RE: 5 BRIGGS STREET

Attached are revised plans for 5 Briggs Street. Through some value engineering we have made some changes that are reflected on the plans. These include:

GRADING & UTILITIES PLAN

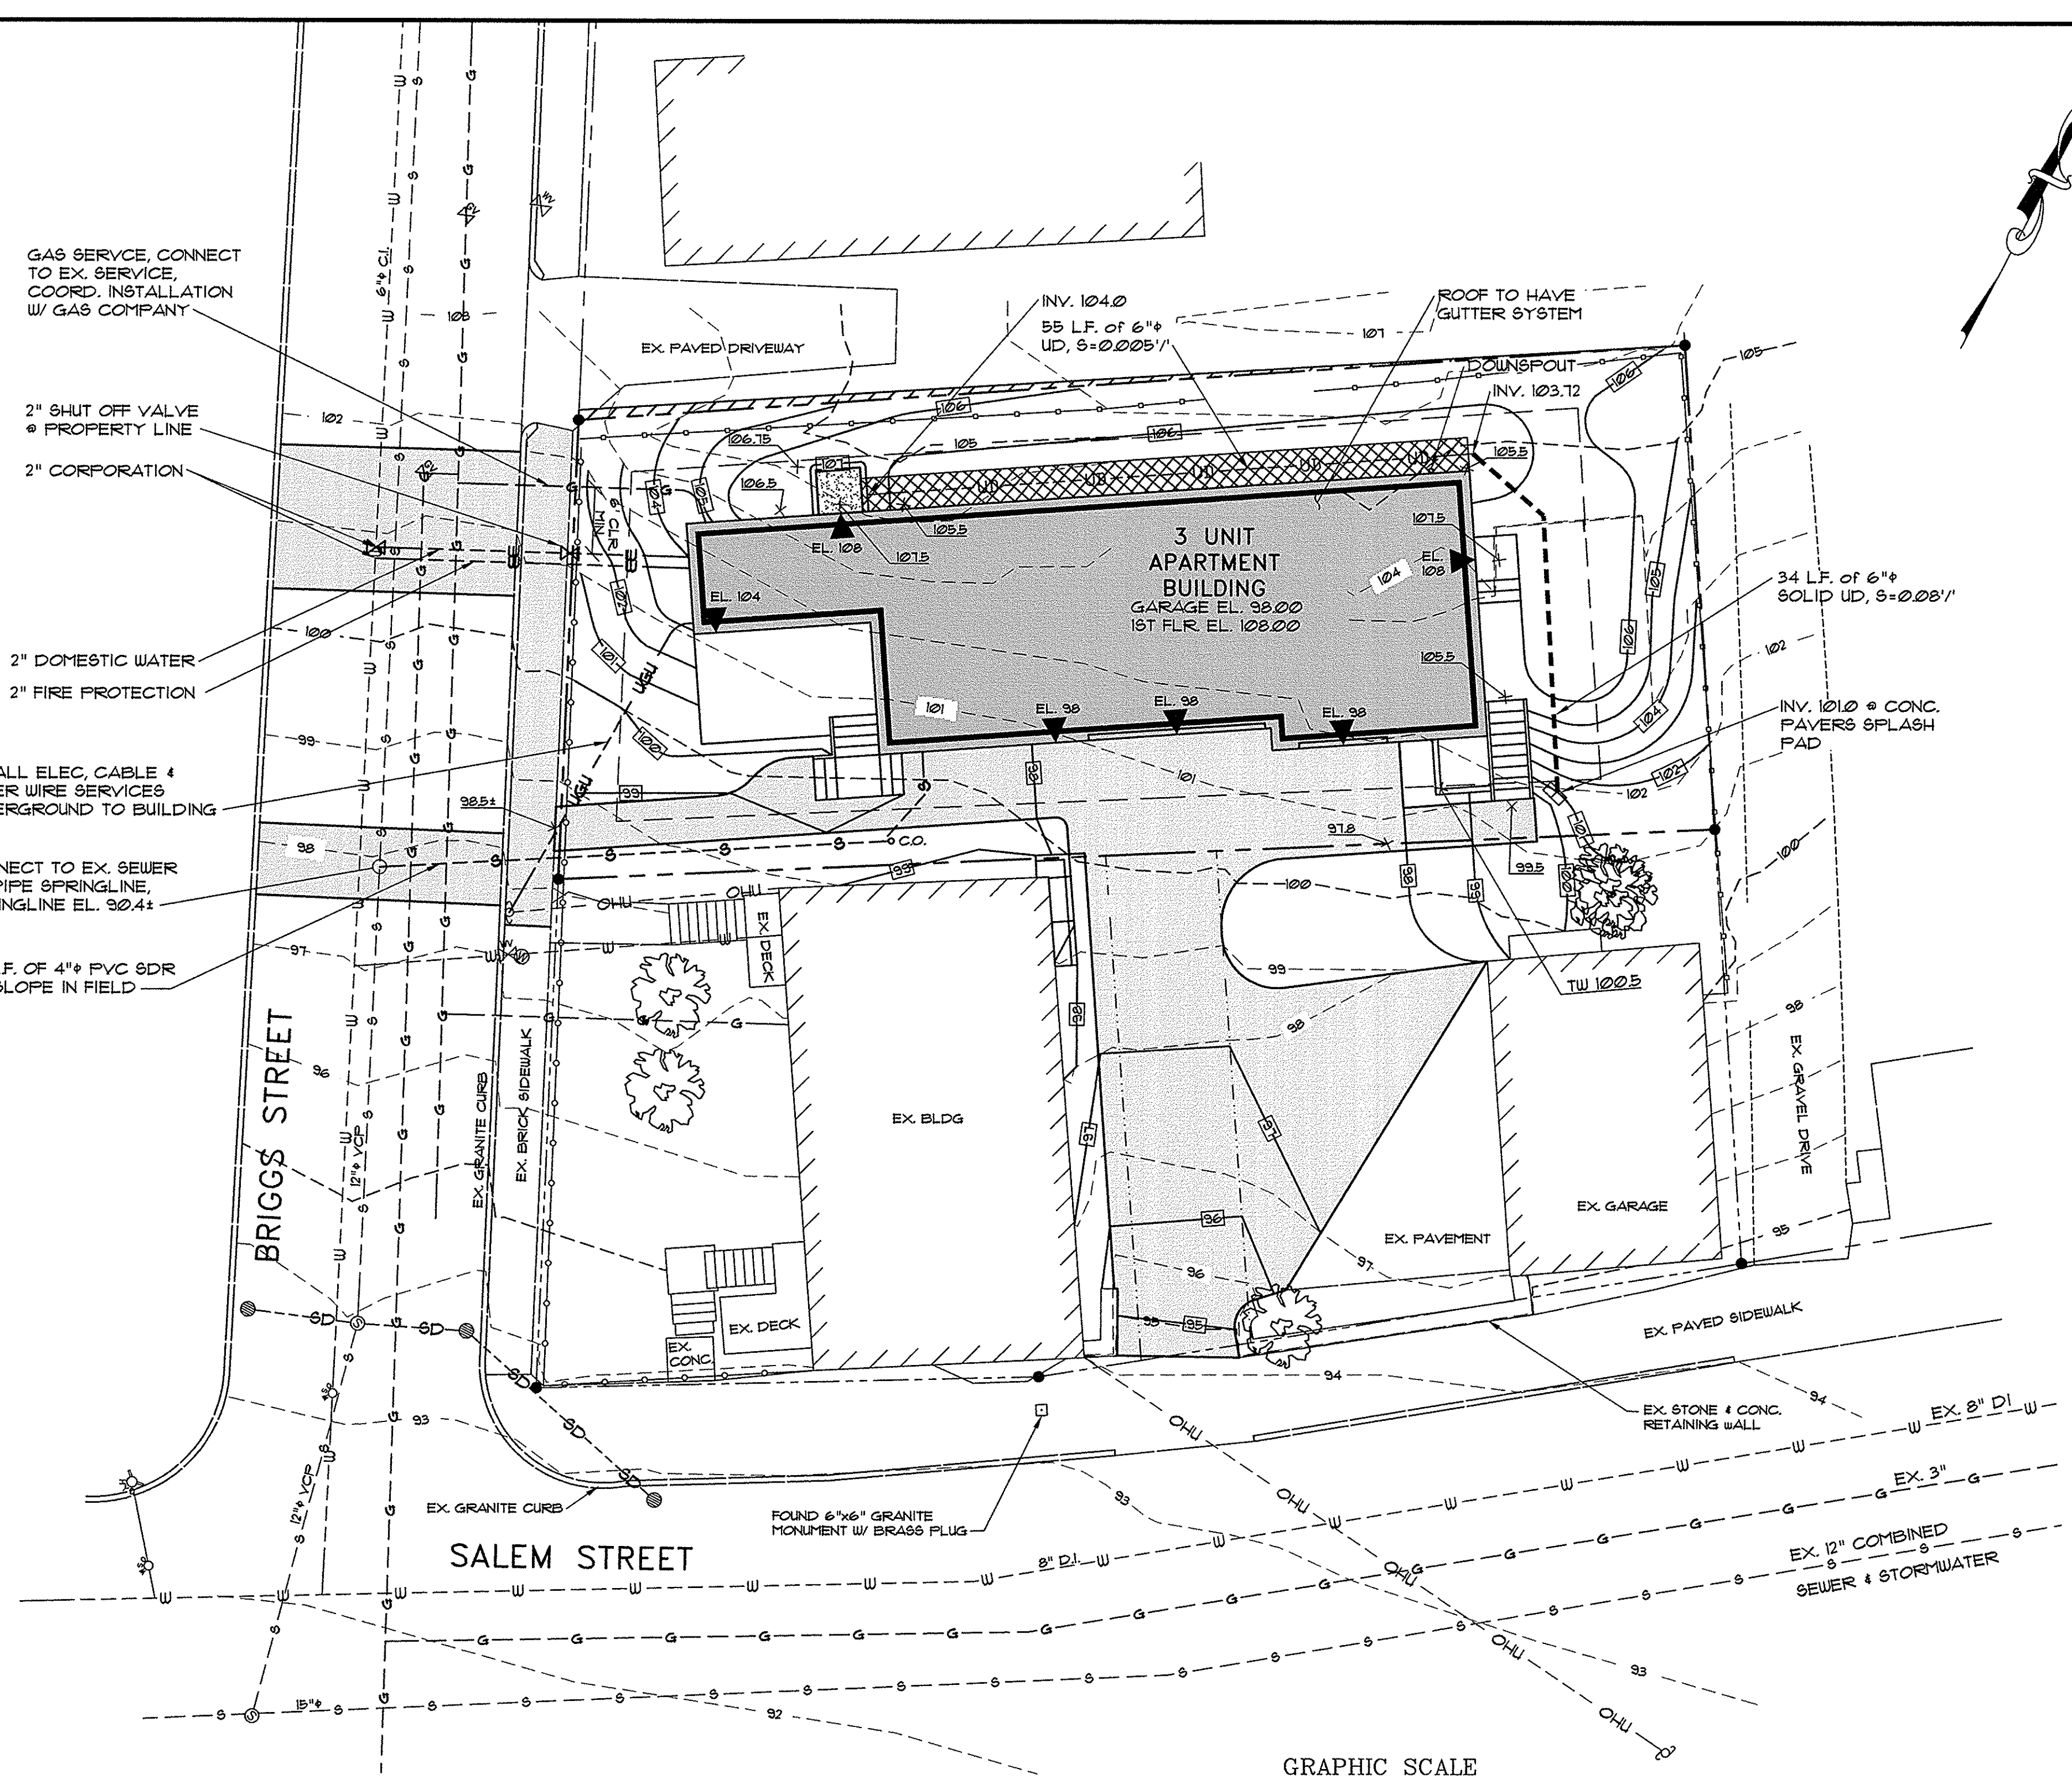
1. Revised the front steps and walkway to consolidate the steps leading to the front door.
2. Removed the rear patio and provided a flat grass area.
3. Removed the retaining walls in the rear yard.
4. Removed the Stormwater Treatment System as the total increase in impervious surface is less than 1,000 sq. ft. It will go from 1,276 sq. ft. to 2,258 sq. ft.
5. The utilities are now located off Briggs Street in conformance with the utility standards. No work on Salem Street is required.
6. We have added catch basin erosion control for the catch basin at the corner of Briggs and Salem.
7. The site has been re-graded to reflect the changes.
